GAROO SOLAR FARM AND BATTERY ENERGY STORAGE SYSTEM (SSD-79747209) TAMWORTH REGIONAL COUNCIL - SUBMISSION RESPONDING TO ENVIRONMENTAL IMPACT STATEMENT (EIS)

Ref: jk/SL DocSet ID 3196455

8 April 2026

Garoo Solar Farm And BESS
 Garoo Road, Garoo
 Site Access Swept Path Assessment

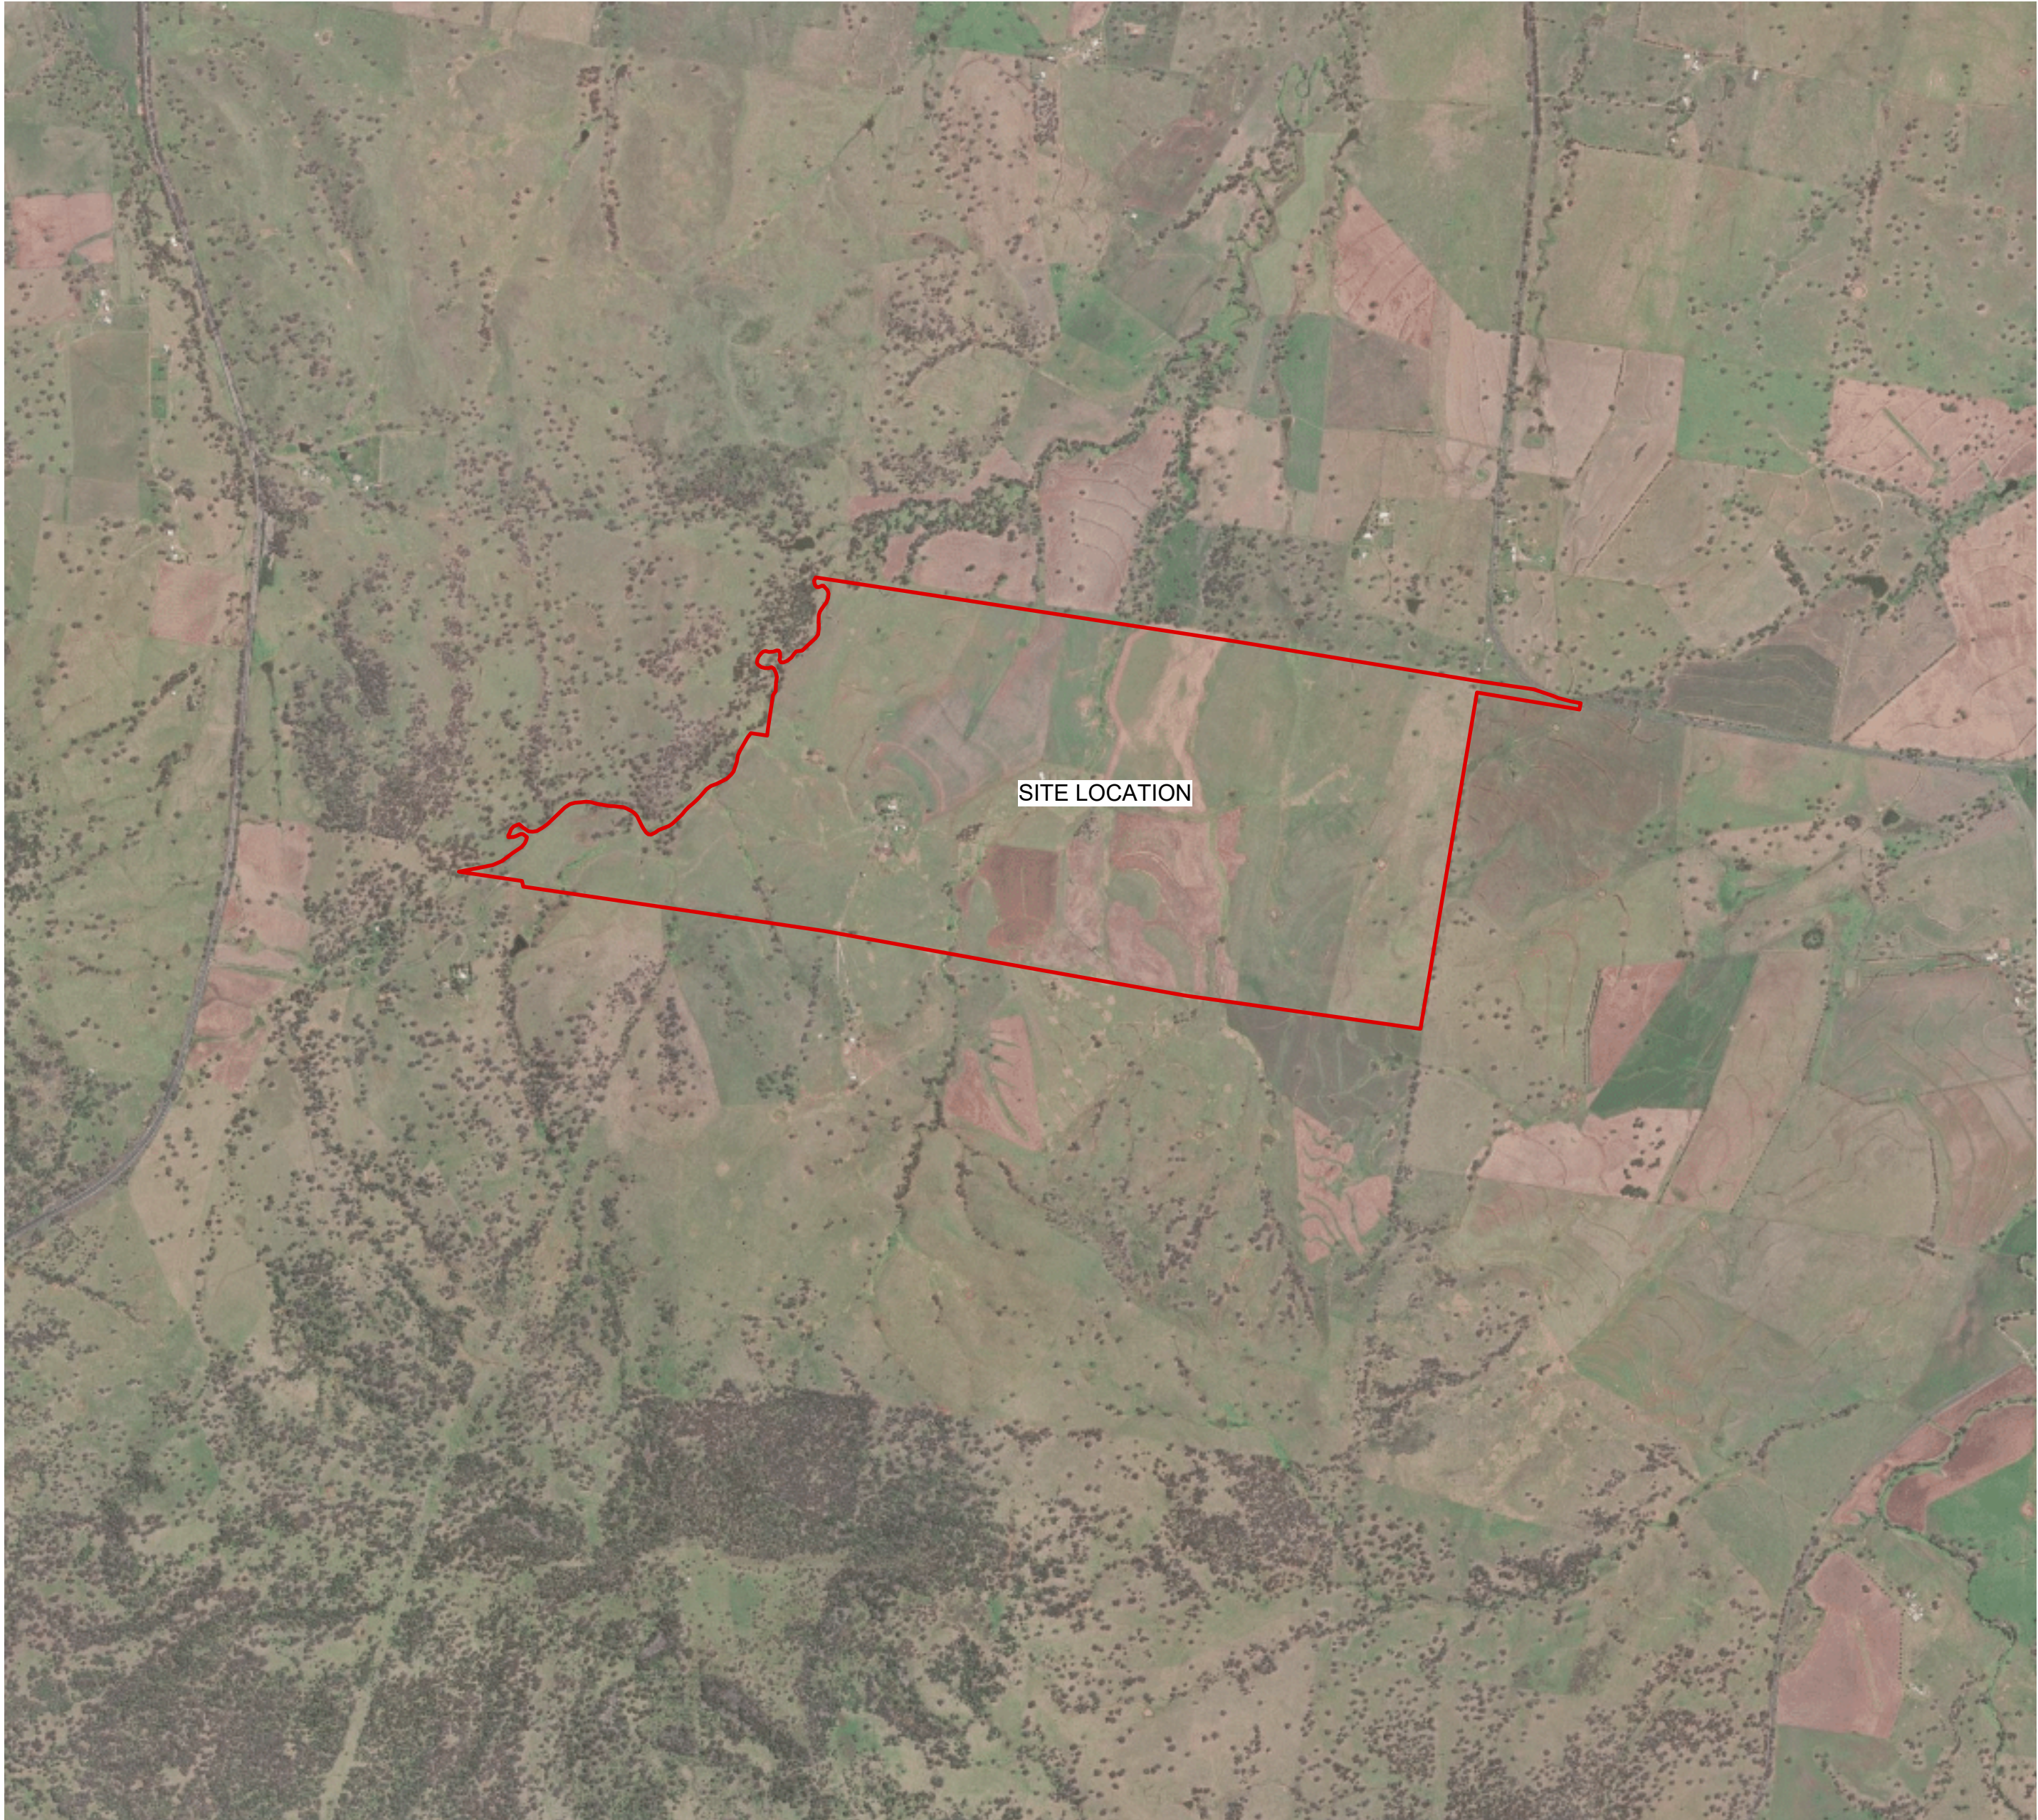
- Council remains concerned about the location and configuration of the proposed site access from Garoo Road. In particular, the access appears to be located on or near a curve, raising questions around available sight distance and the ability for vehicles to safely enter and exit the site without “straight-lining” movements across the carriageway.
- Council considers that the final design should demonstrate adequate safe stopping sight distance and confirm that vehicle turning paths can be accommodated safely and efficiently under peak construction traffic conditions.
